ADDRESS : 1290 COKESBURY RD SUBDIV:
 CONTRACTOR : MJ ROSE HOMES, LLC PHONE : (919) 369-3714
 OWNER : PATTEN DENNIS J & JENNIFER M PHONE :
 PARCEL : 05-0633- - -0209- -03-
 APPL NUMBER: 17-50041554 CP NEW RESIDENTIAL (SFD)
 DIRECTIONS : T/S: 06/05/2017 03:19 PM BPETRICH --
 SITE IS ON SAME PARCEL AS 1260
 COKESBURY ROAD - FOLLOW LONG DIRT
 DRIVEWAY BACK TO HOUSE SITE. TAKE 401 N
 OUT OF LILLINGTON - LEFT ONTO CHRISTIAN
 LIGHT ROAD - LEFT ONTO COKESBURY ROAD -
 GO APPROX 3 MILES AND DRIVEWAY IS NEXT
 TO THE HARNETT COUNTY SOLID WASTE
 TRANSFER STATION.

VIOLATION NOTICE

Job Name: MJ ROSE Date: 1/12/18

1ST FLOOR FRAMING PLAN

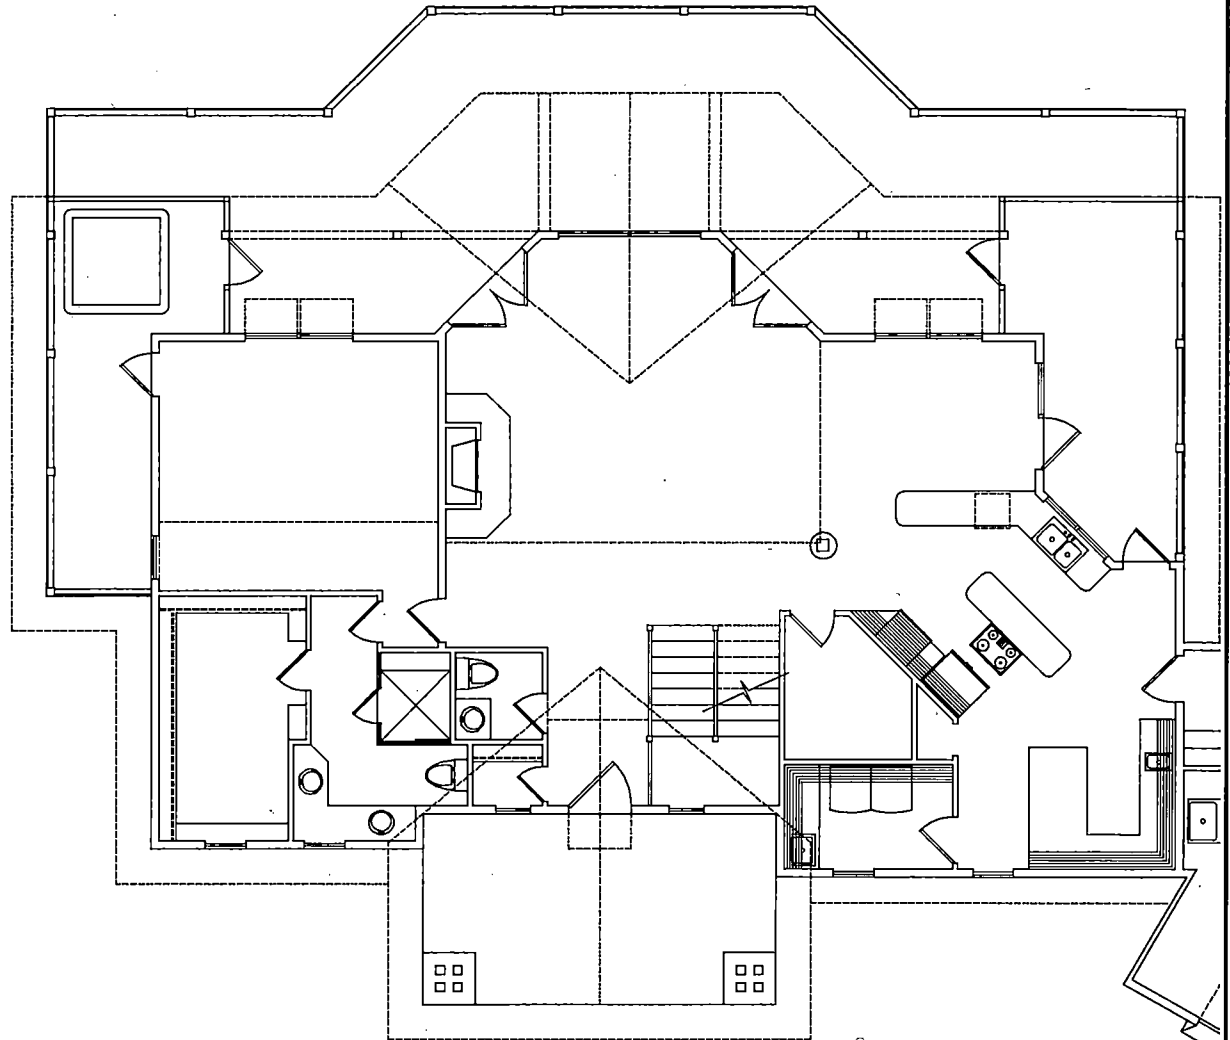
Violations Found: ① MUST MAINTAIN BARRIER Between white wood s
MASONRY AT FLOW JOIST REPAIR. ② Still missing LOAD
POINTS circled on PLANS
